From: Contact Centre (CRM) <contact@ribblevalley.gov.uk>
Sent: 03 June 2022 13:20
To: Planning
Subject: Planning Application Comments - 3/2022/0449

Planning Application Reference No.: 3/2022/0449

Address of Development: Lower Abbott House
Abbott Brow
Osbaldeston

proposed elevations

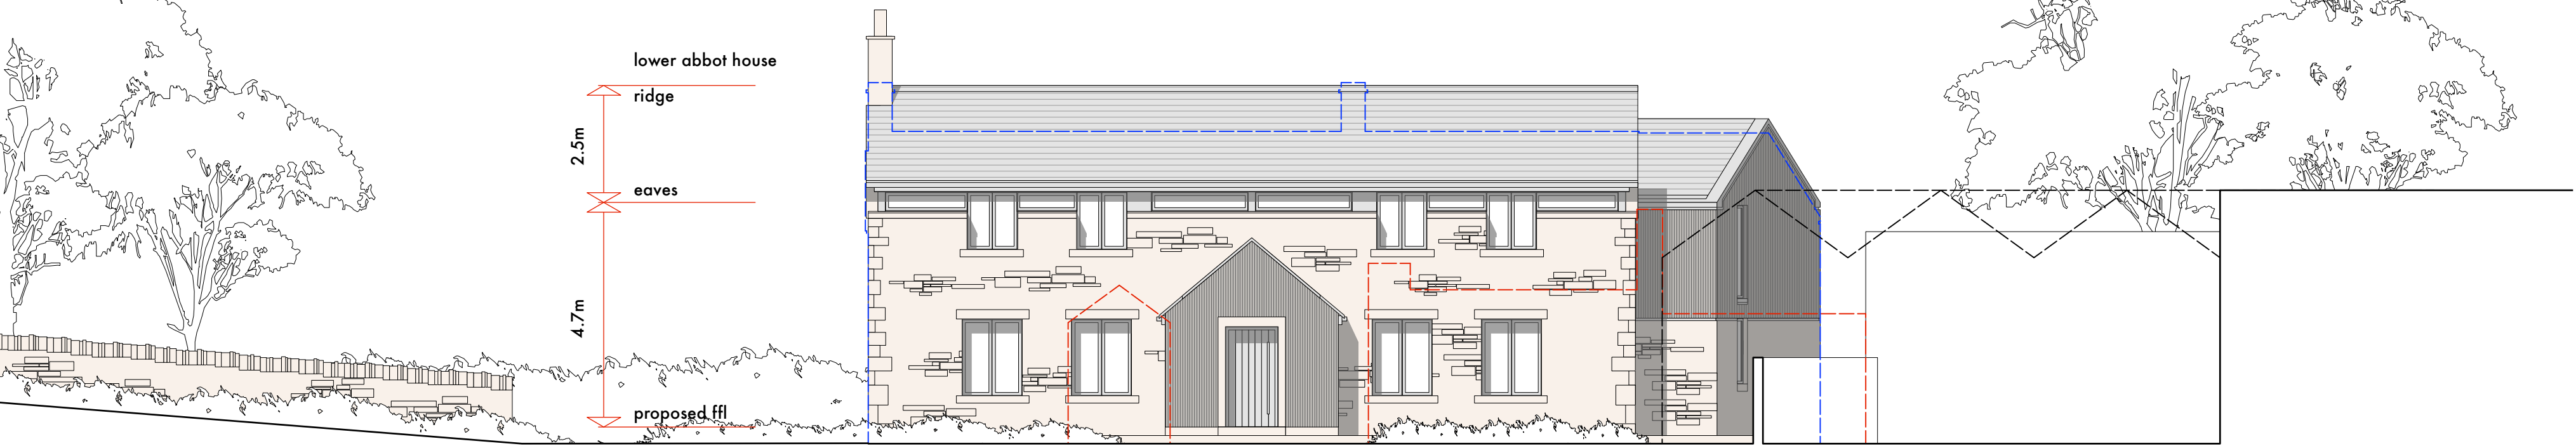
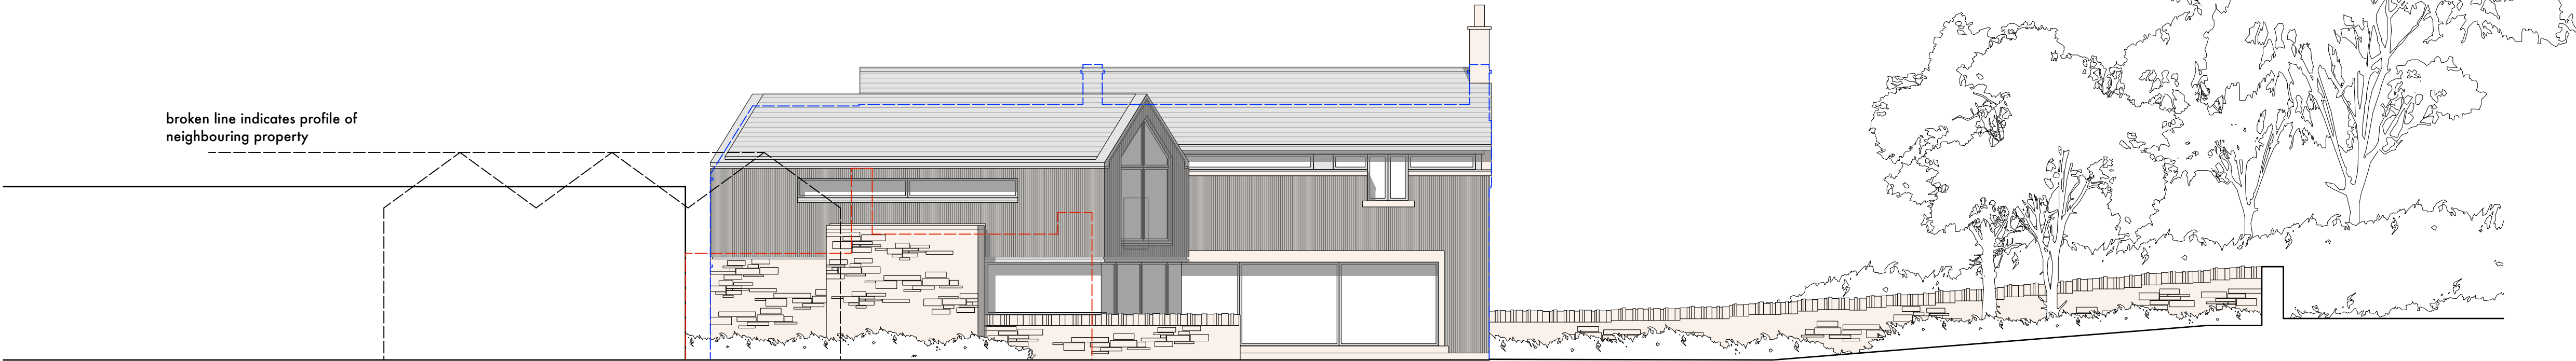
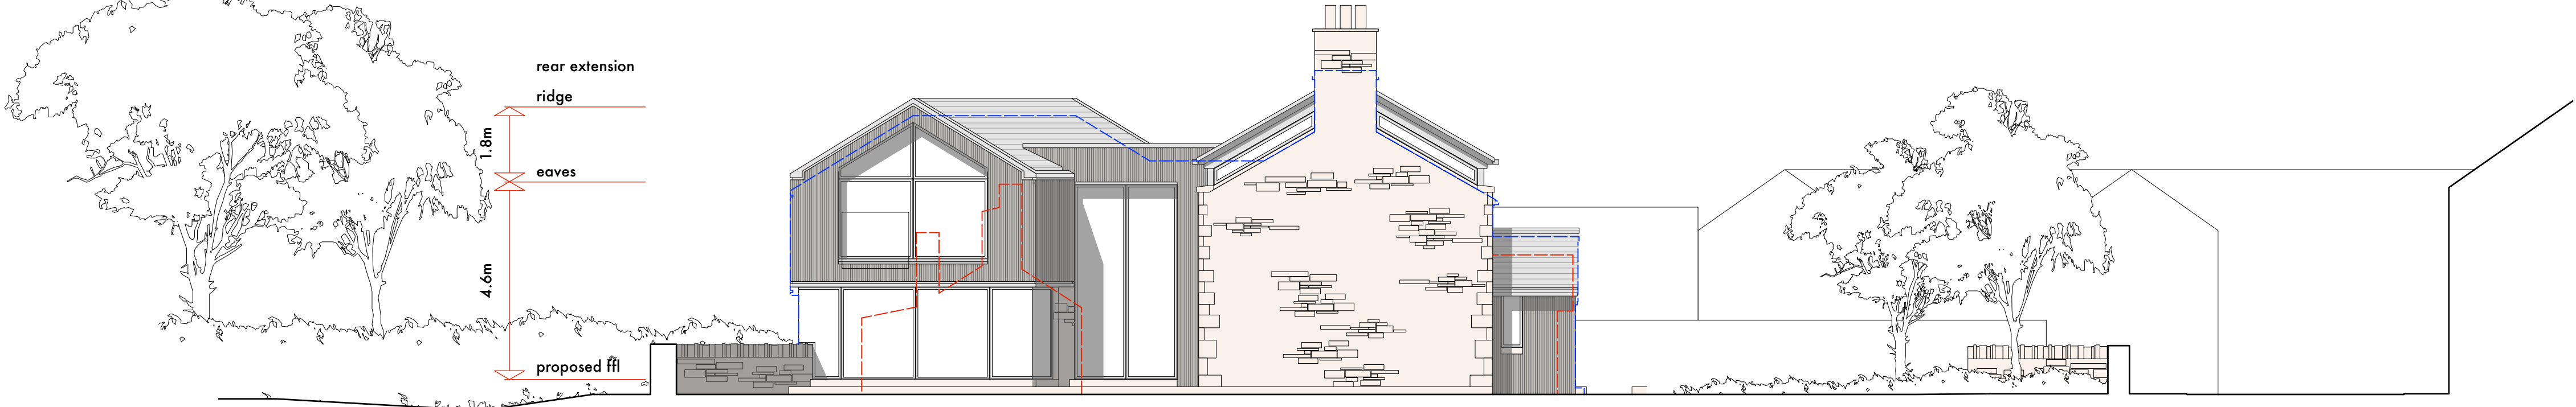
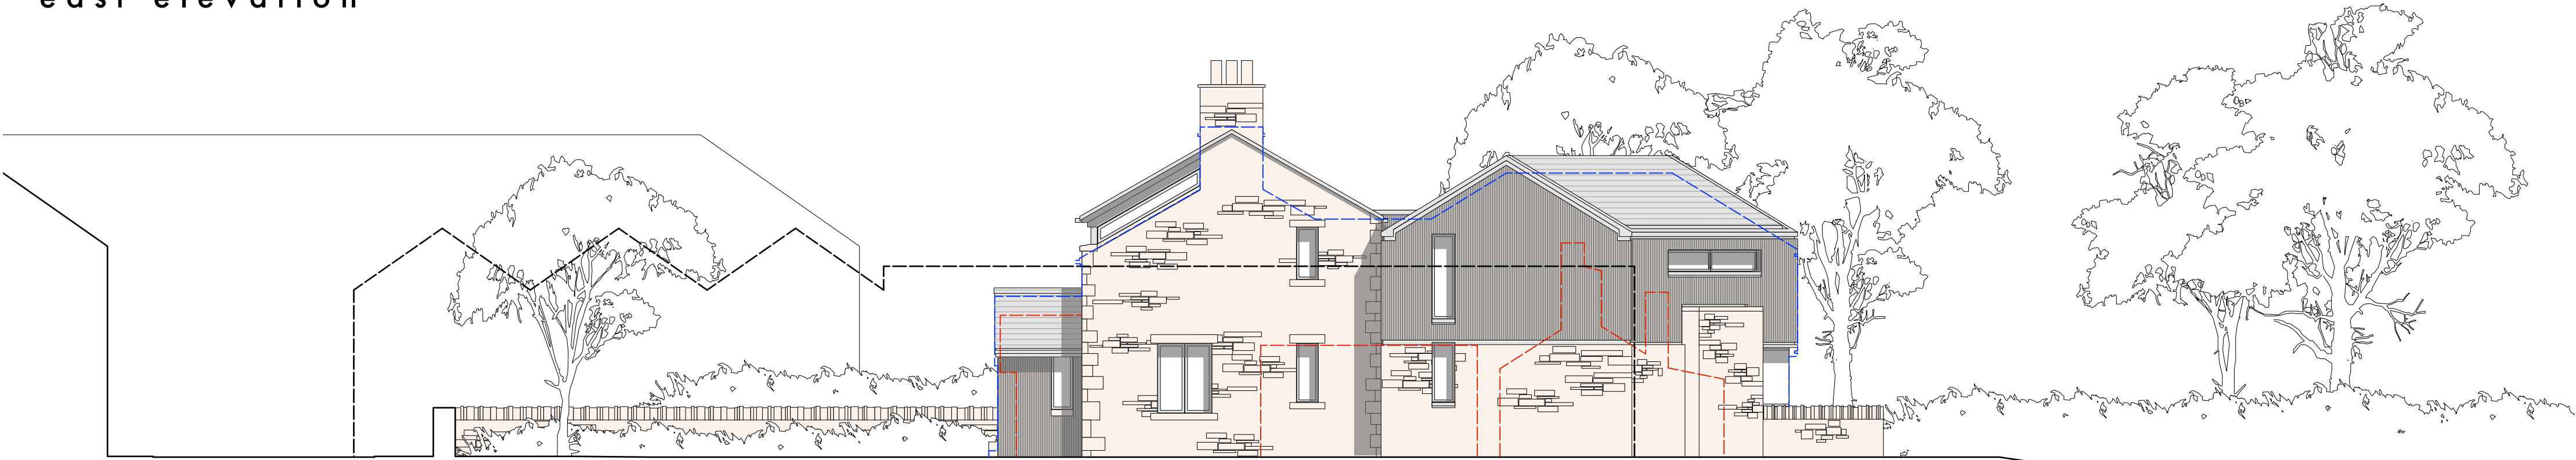
Raising of the ridge height.

The property and the properties directly across Abbott Brow have what is described as limited headroom but adequate and again in keeping with the type of properties in the immediate vicinity. The property was purchased with these measurements and lived in for approximately 200 years previously, and should remain the same height. The sun setting over Lower Abbott House with a raised ridge height would reduce the light to the four properties directly across Abbott Brow. (Lower Abbott House Farm, Melwyn, Lynton, Lower Abbott Cottage).

The proposal of timber cladding is NOT in keeping with any of the existing properties in the vicinity and would in my eyes degrade the appearance of Abbott Brow. The front porch has had many positive comments over the years and must be retained. No cladding to the property at all.

2 With regards to materials of the proposed new building. There is mention of Timber boarding/cladding. There are no properties in this area with timber cladding. This is not in keeping with other properties and it should be natural stone only. Timber cladding needs maintenance and is a fire hazard.

3 Design Statement: 'Request to raise the ridge height of the previously approved scheme by a nominal amount (1 metre)':

One metre is by no means a nominal amount. To raise the roof of the property by 3 feet 3 inches is going to block the light for the properties opposite, especially [REDACTED] and completely transforms the look of the property.

4 The front and side elevations should be maintained in the original stonework for appearance and to fit in with other neighbouring properties.

first floor plan

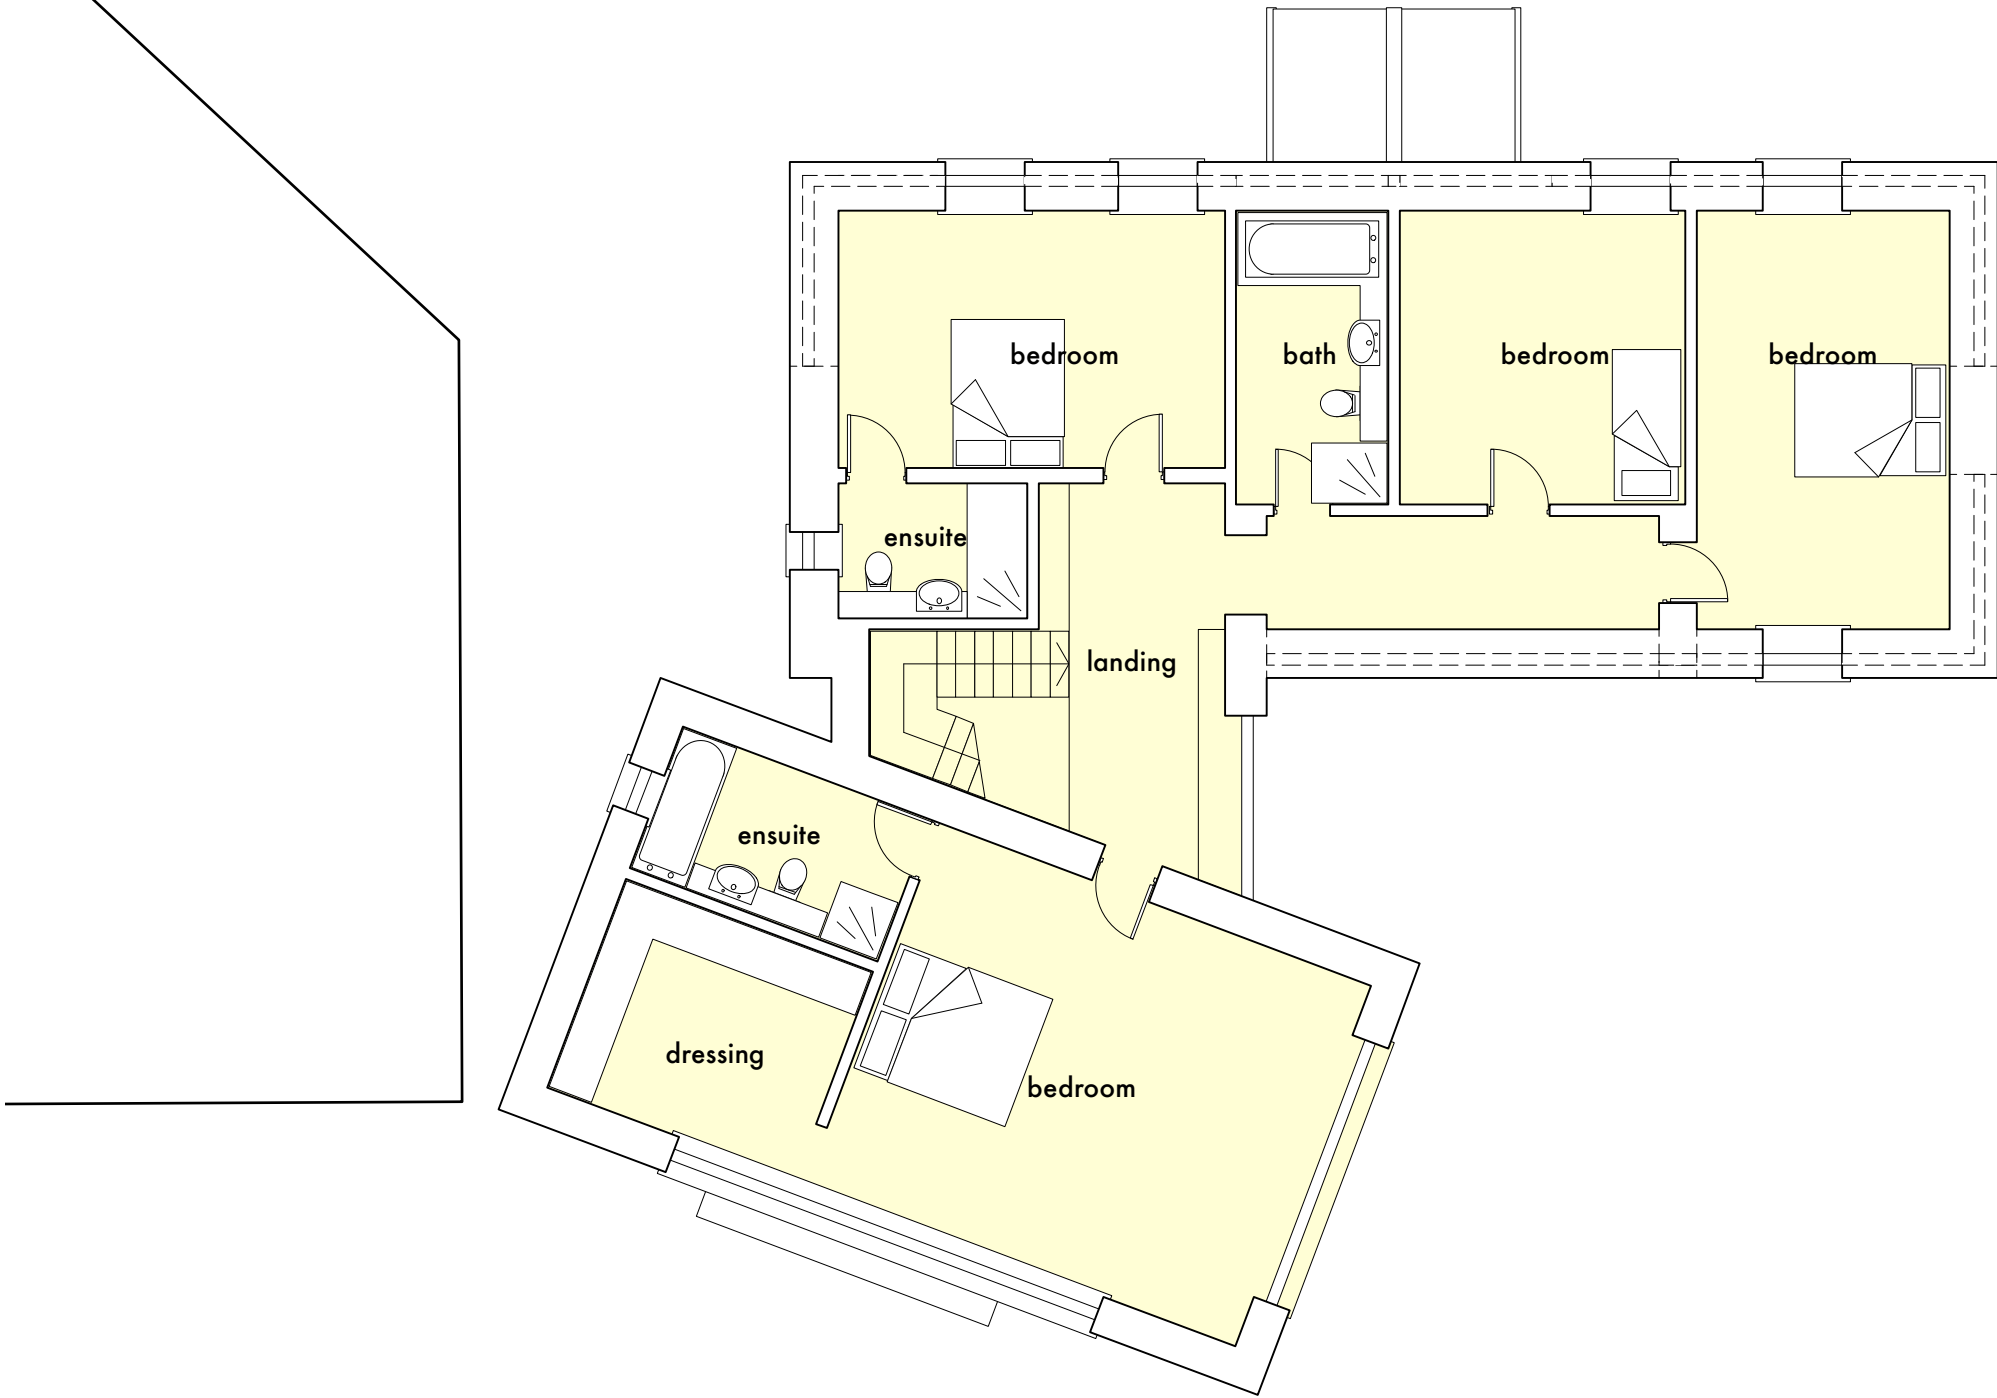
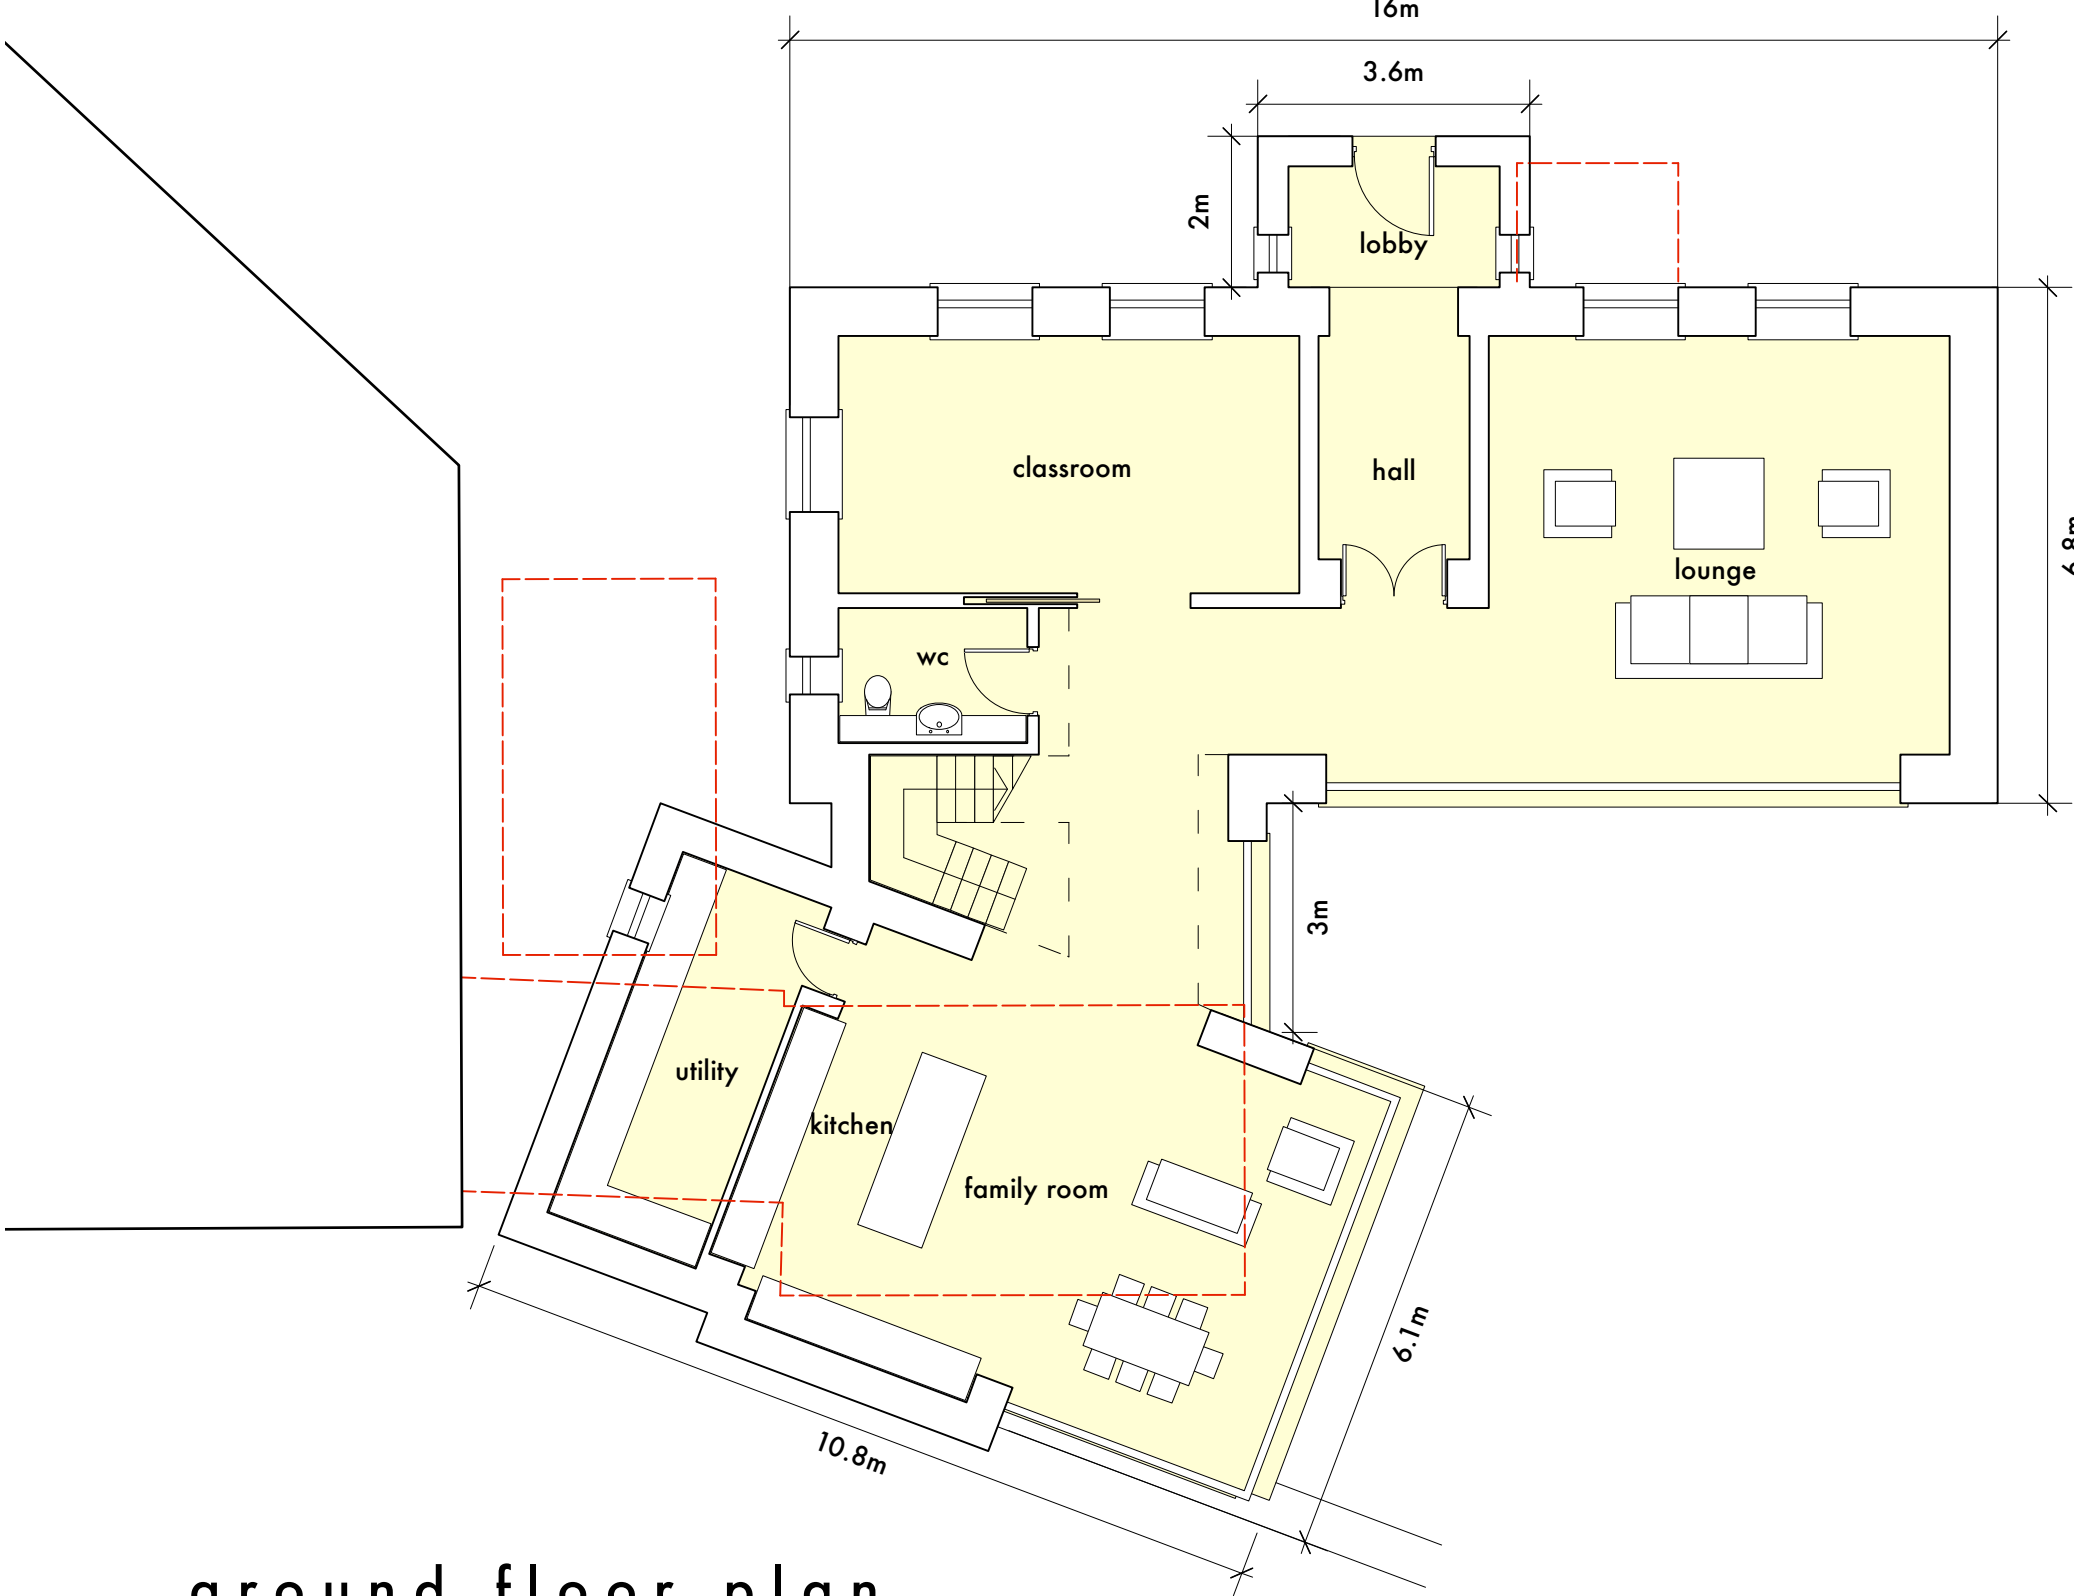
5. The proposed extension illustrates a large first floor window facing SE . It may as has been noted on the previous application [REDACTED]

[REDACTED] . We would ask that if this extension is built as currently designed the size of this bedroom window be reduced .
